FARGRO, THE VINERY, POLING

Thank you for your email of 26 June sending a Transport Statement in support of planning application A/74/13/ for a proposed distribution warehouse and covered storage, trade counter and associated offices. The application includes the upgrading of the access road and improvement of the existing junction with the A27. We note that this application is a Departure from the Development Plan and also affects a public Right of Way.

This letter reviews the Transport Statement prepared by Millwood House Consultants that was issued to us on 26 June.

CLIENT	
DRAWING	
EXISTING AND PROPOSED ENTRANCE LAYOUT	
DO NOT SCALE FROM THIS DRAWING. THIS DRAWING IS COPYRIGHT ©

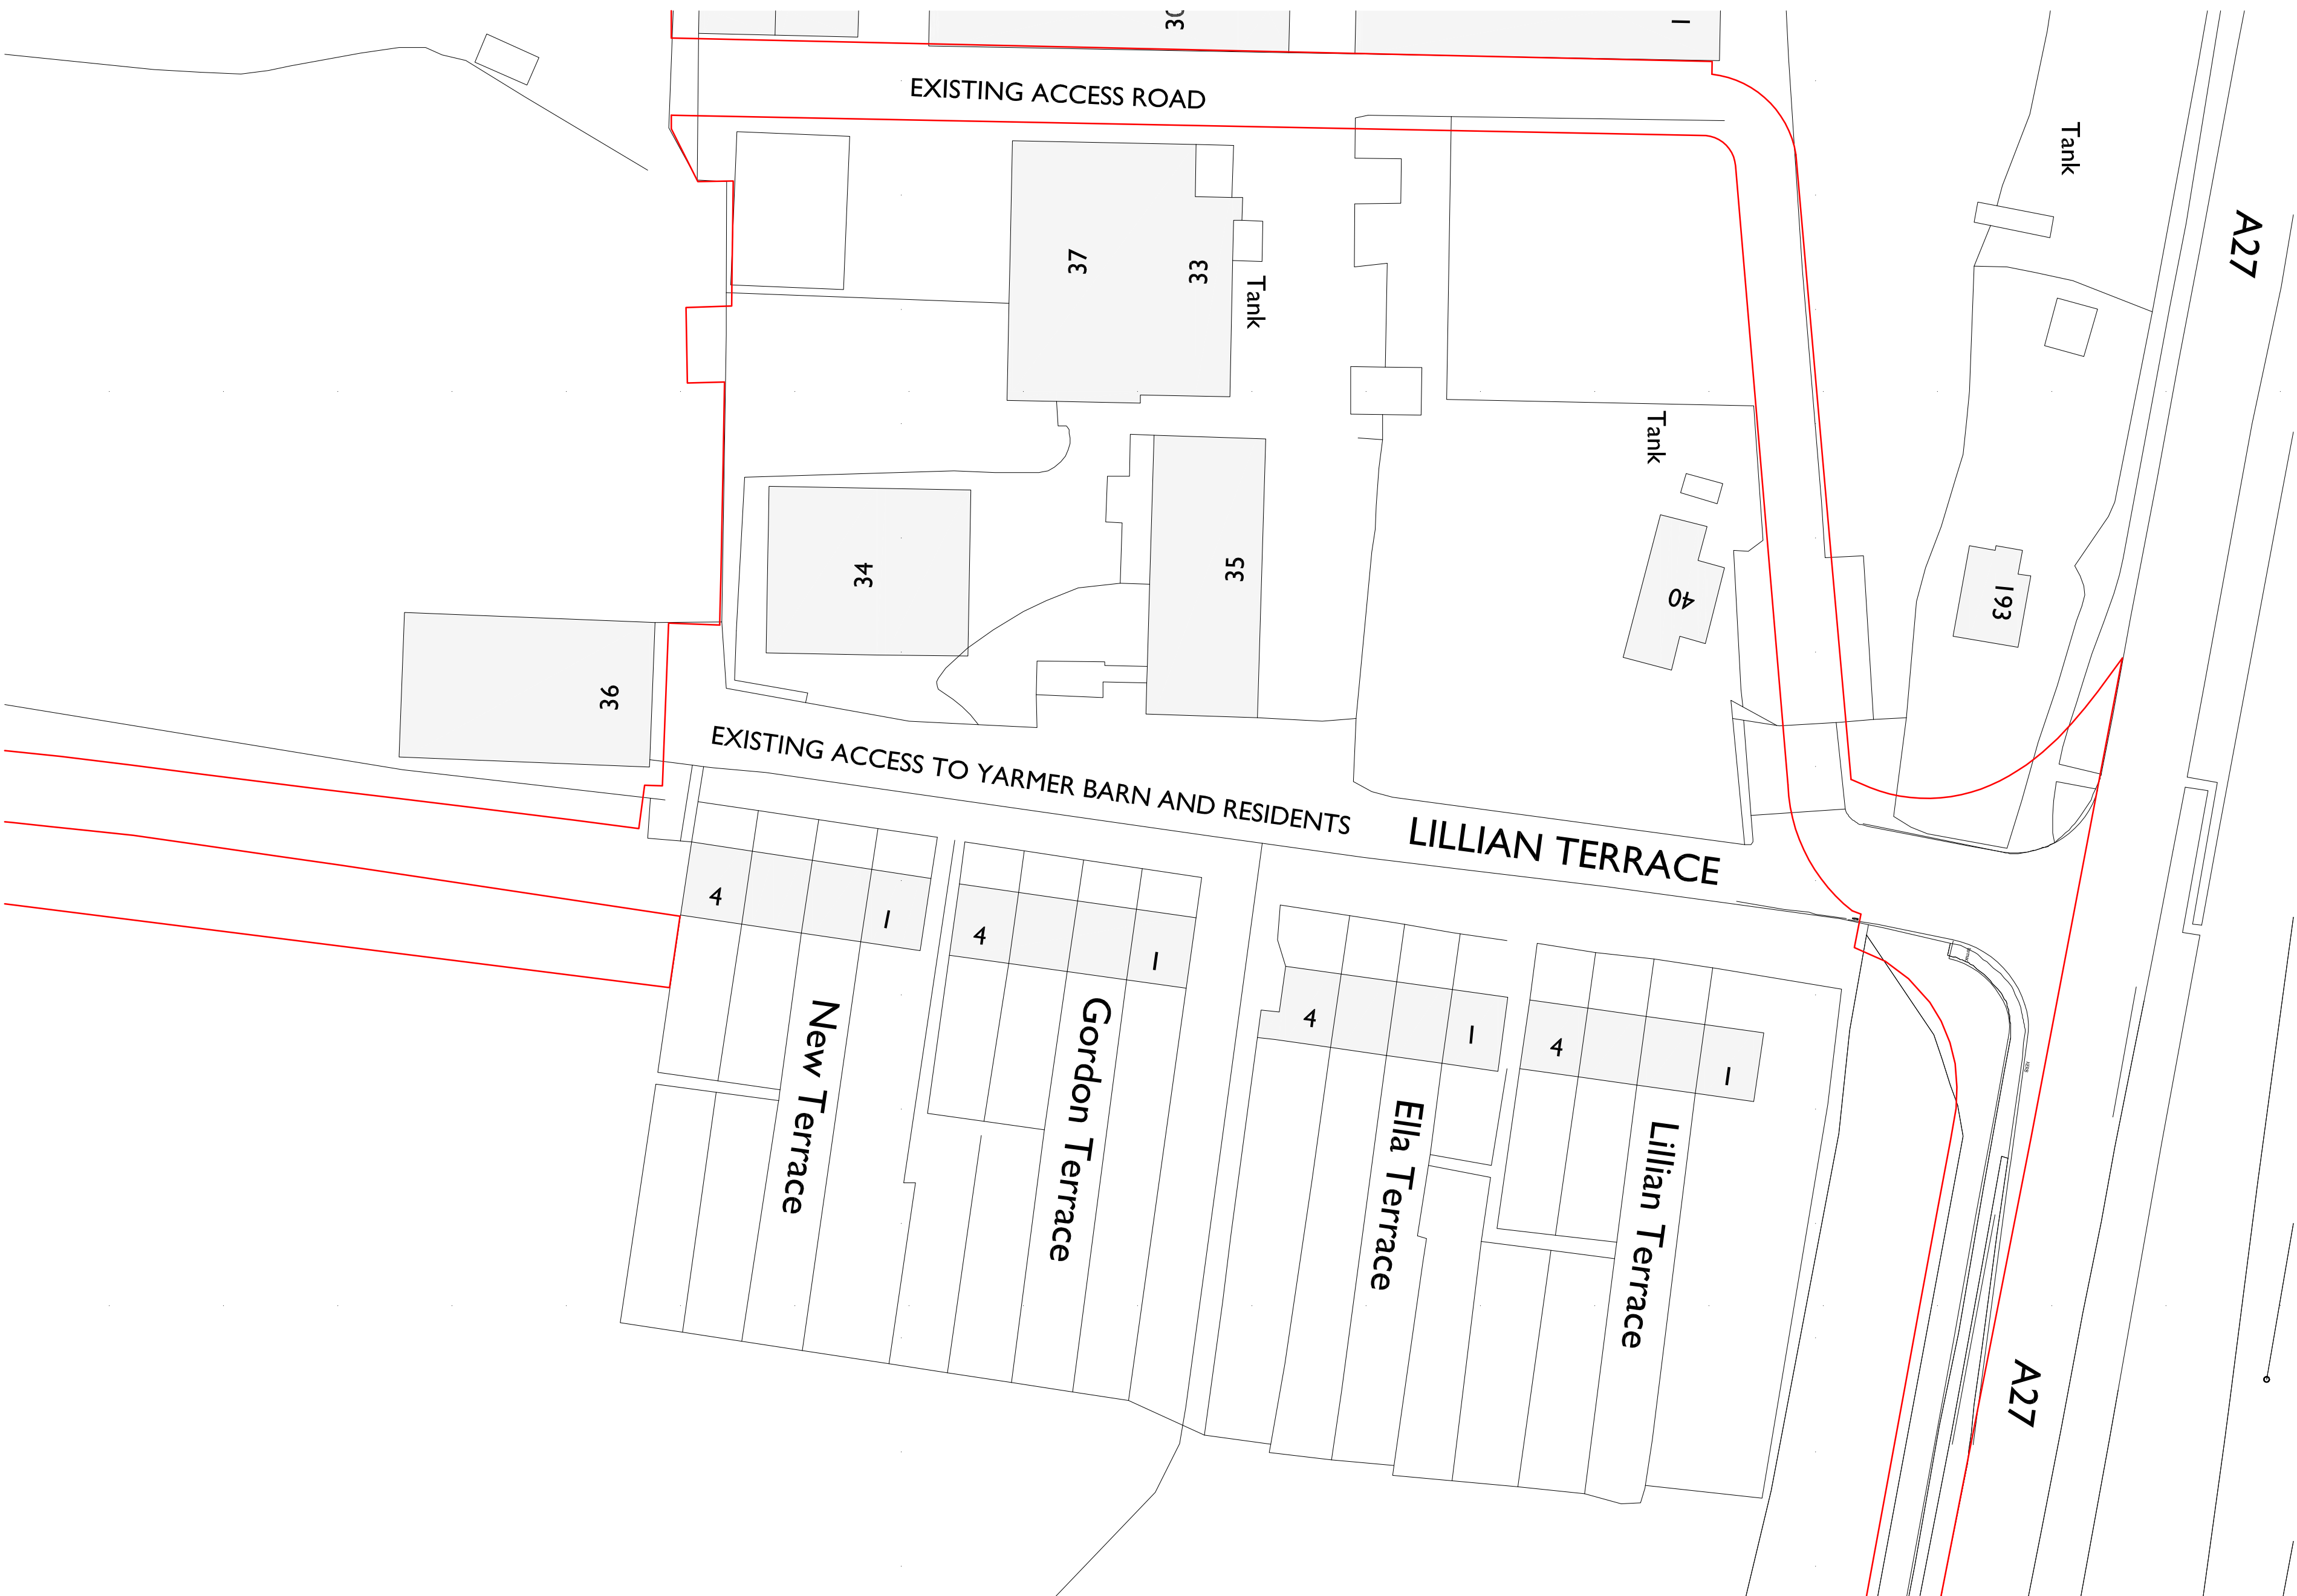
The Transport Statement contains information on the revised access proposals which we examined as part of our initial consultation response to Arun. The proposal to improve the junction is broadly acceptable in its compliance with highway standards, and in our letter to Arun we outlined our formal processes for progressing the design. We also issued a detailed technical note which examined the proposals against the Design Manual for Roads and Bridges (DMRB) standards.
